Fire Marshal Division

Re: Full Gospel Tabernacle Church
3661 NC Hwy 55
Dunn, NC 28335

Application Number BCOM1809-0004

A1.1

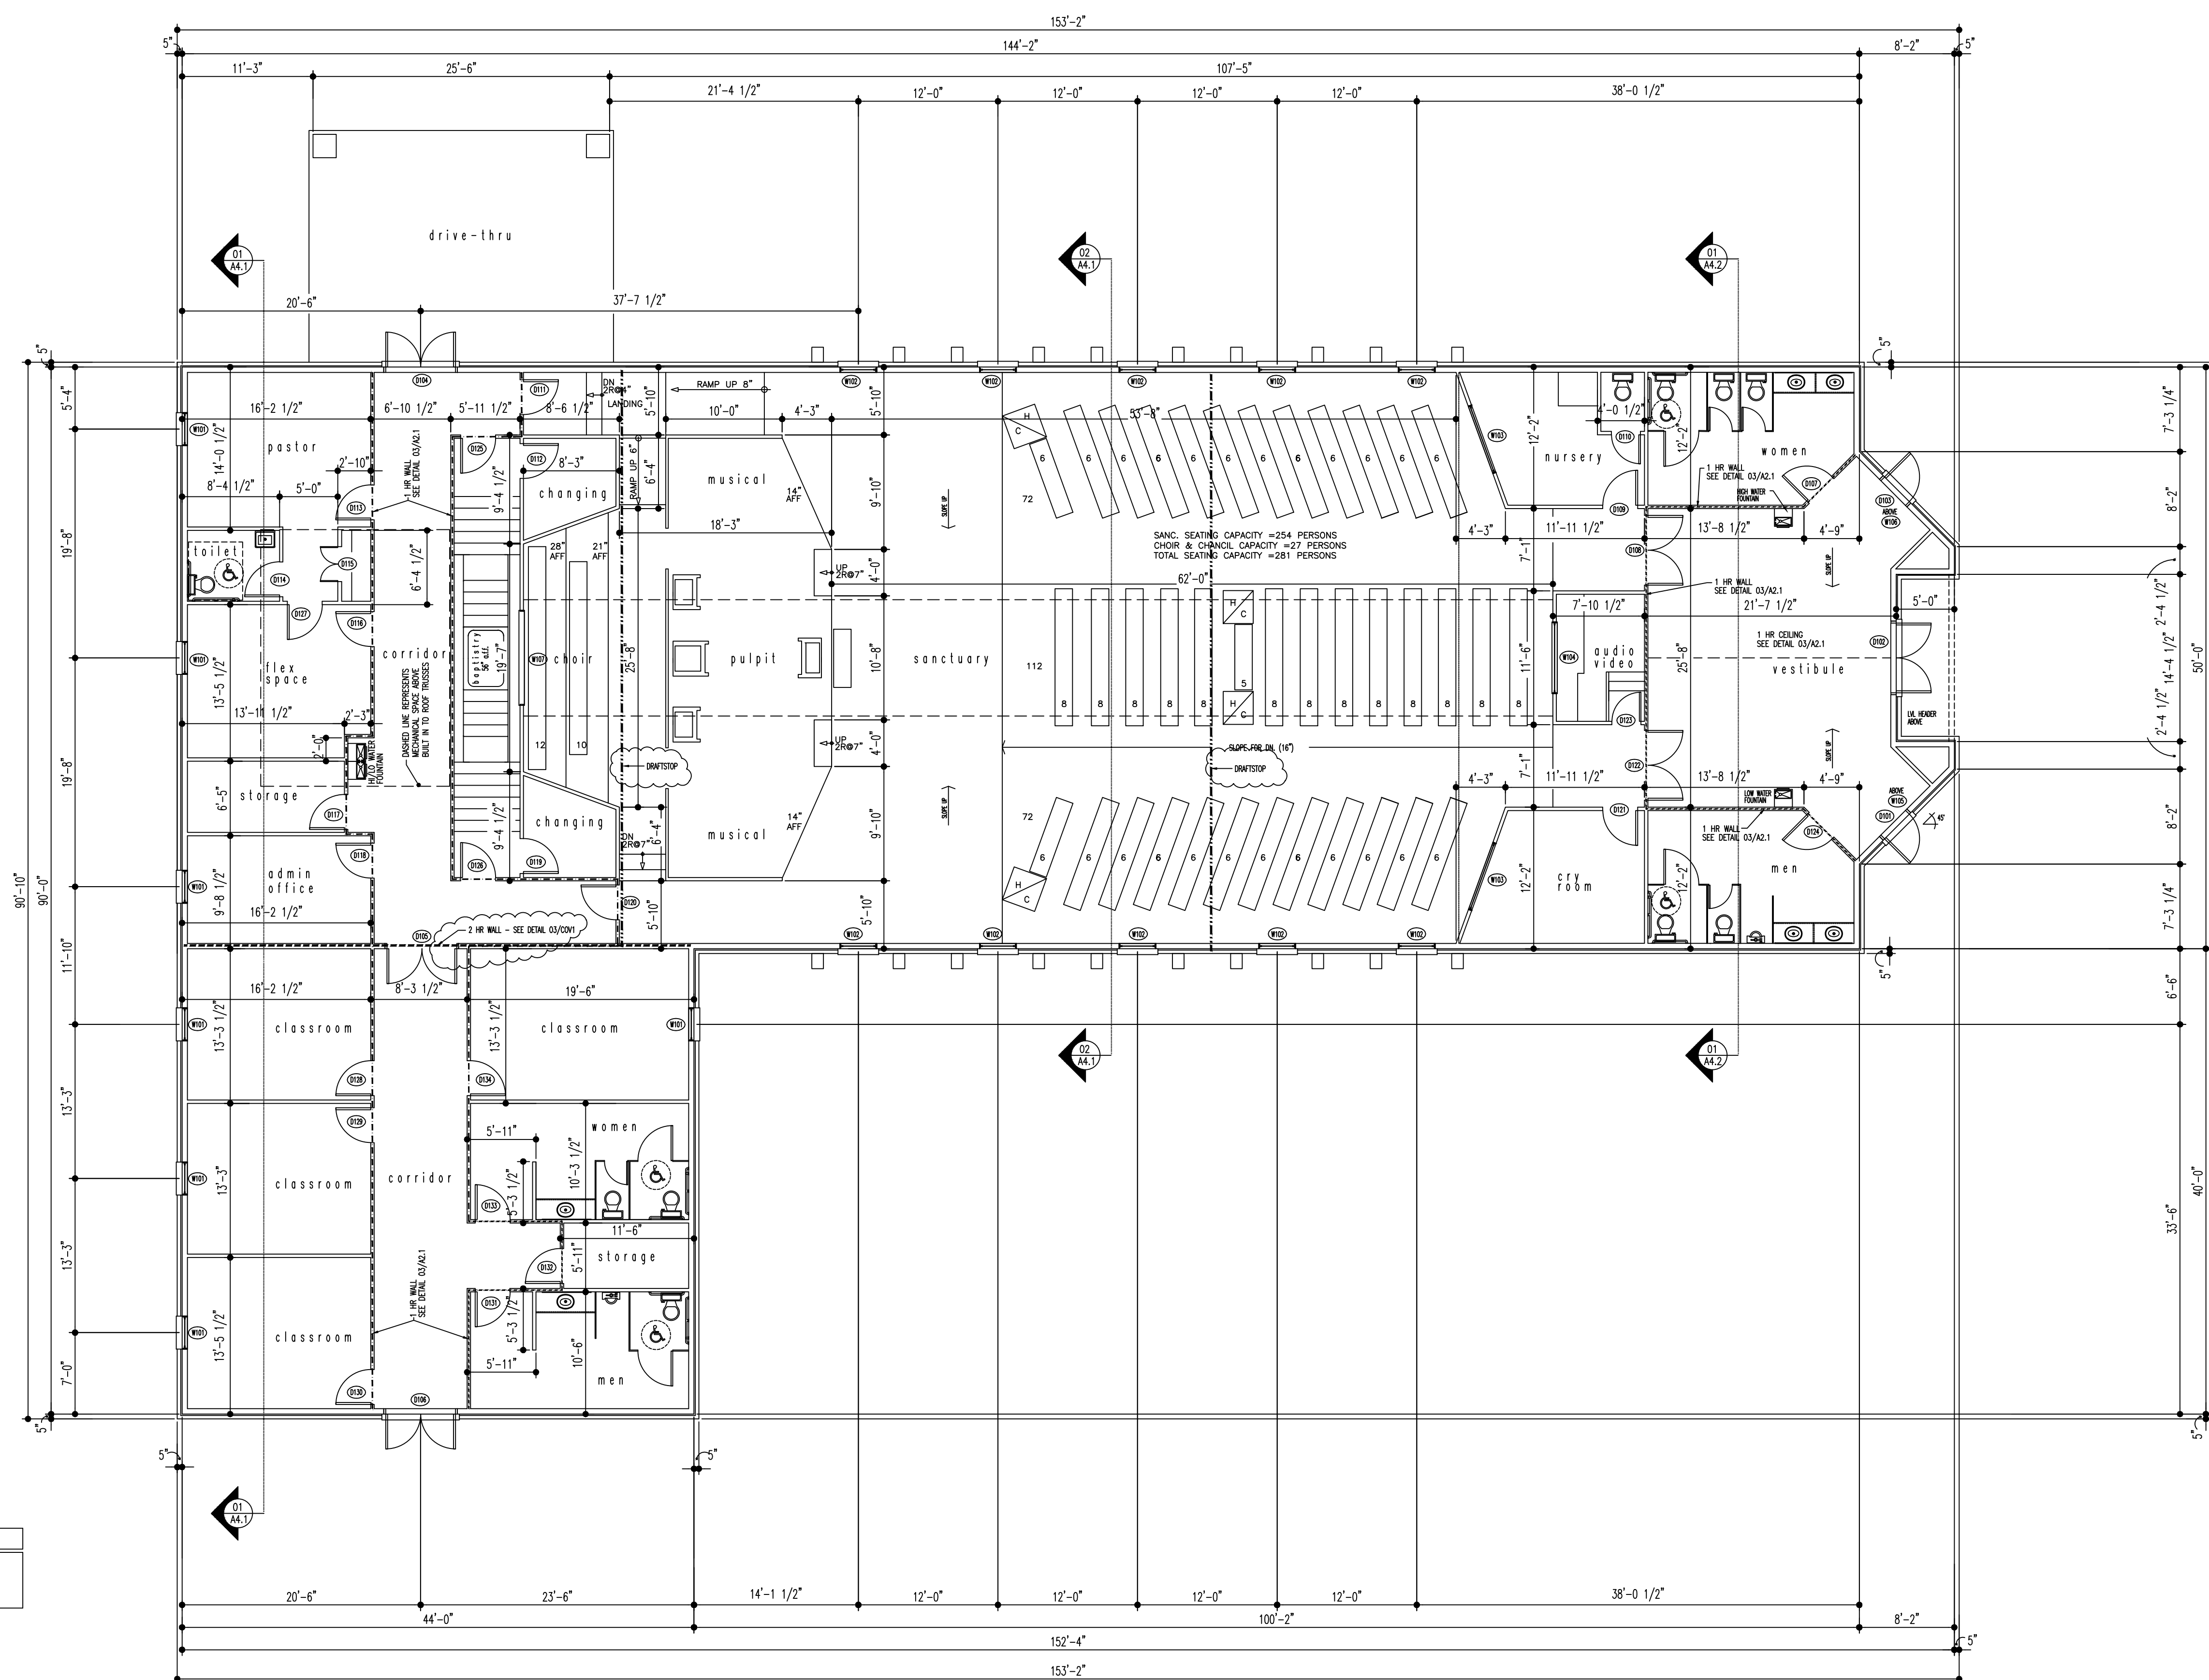
- **508.2.5.1 Fire-resistance-rated Separation**
 - Required separation where noted walls indicate “1 Hour Wall Sheet A2.1” should be listed at a 2 Hour Rating per referenced code.
